As conditions for approval of the Bent Grass Meadows/Meridian Road signalization construction documents Challenger Communities agrees to include, or shall consider the recommendation, of the following items:

SIGNAGE AND STRIPING PLAN

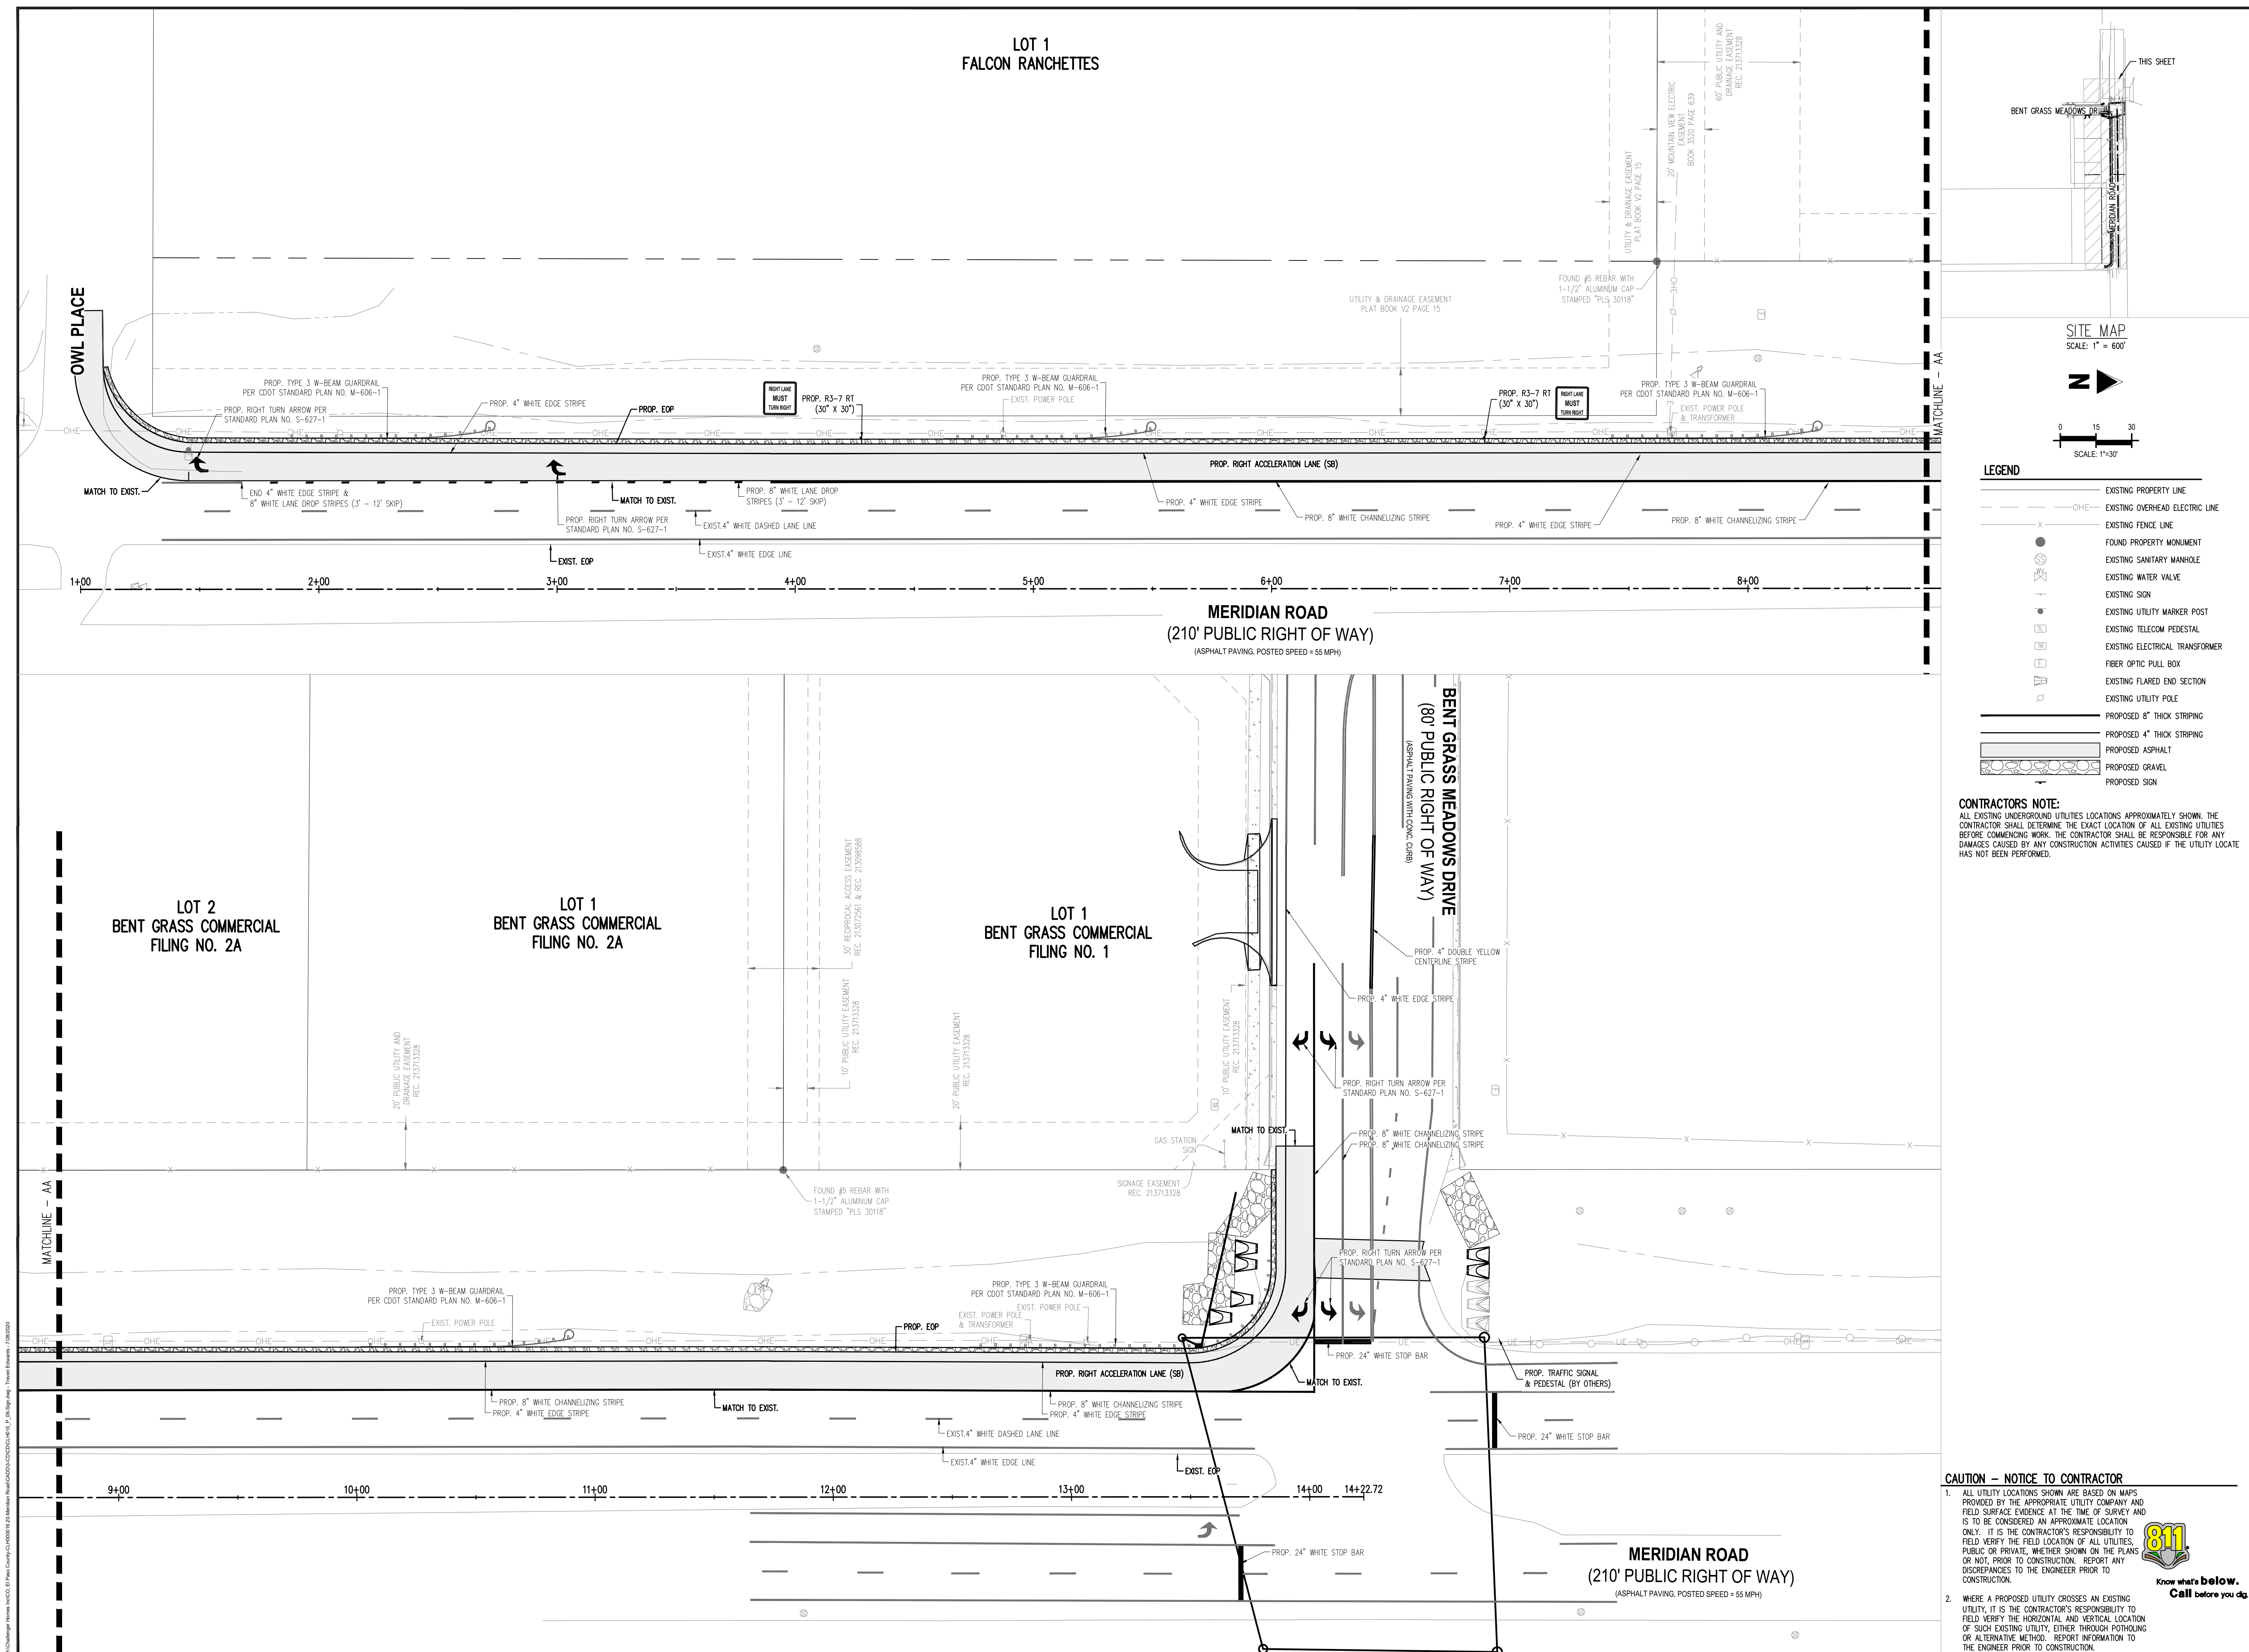
- a. Address in the comment response or a TIS follow-up memo the need/warrants for the protected northbound left turn (is the permissive green not sufficient?). If the phasing is adjusted, revise the plans as appropriate.

- b. A channelizing island is recommended at the southwest corner of the intersection. This would provide benefits for the eastbound right turn movement and possibly a better location for the signal pole. Truck tracking and proper drainage will need to be verified. If design time constraints are an issue and the island is recommended, revisions to the plans can be submitted when available.

- c. A third northbound overhead ball is recommended – this could be located with “1” as a 5-section head on the channelization lane line or separately at least 8’ from the lane line (verify signal spacing if added).

- d. For the southbound movement add a third 3-section head, min. 8’ from lane line (verify spacing).
- e. Remove the “8” for the eastbound right.
- f. For “6” and “7”, since there is no conflicting left turn a red ball should be used above the arrows and the head centered on each lane.

- g. Add two R3-5L signs for the eastbound left turns, next to the signals.
- h. Add a R3-5R sign for the eastbound right turn lane.
- i. Recommended that “4” be removed.

- j. Ensure that overhead street name signs follow MUTCD Table 2D-2 design (24” tall, 12” and 9” lettering).
